DRB Application No.: 06DRB-01037 (P&F)	Project # 1004858
Project Name MANDELL BUS & RES. ADDITION	
Agent: Surveys Southwest Ltd.	Phone No.: 998-0303a

# DRB CASE ACTION LOG (PREL & FINAL PLAT)

**DRB CASE NO/PROJECT NO: 1004858**

**RE: Mandell Business & Residence Addition/sketch**

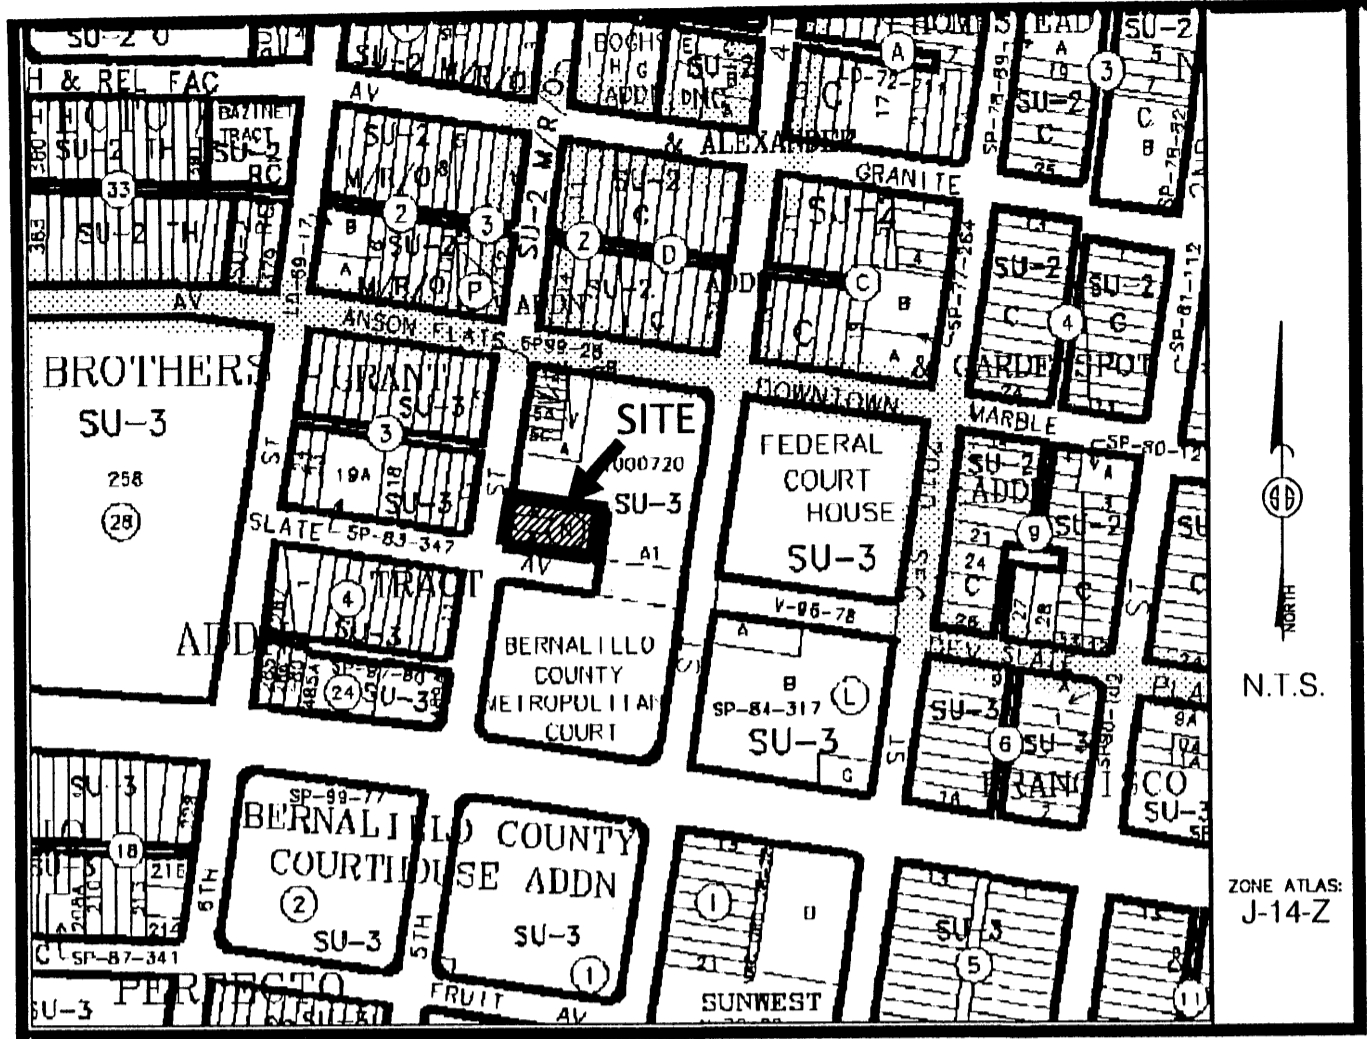
TRANSPORTATION: 10' Radius @ alley
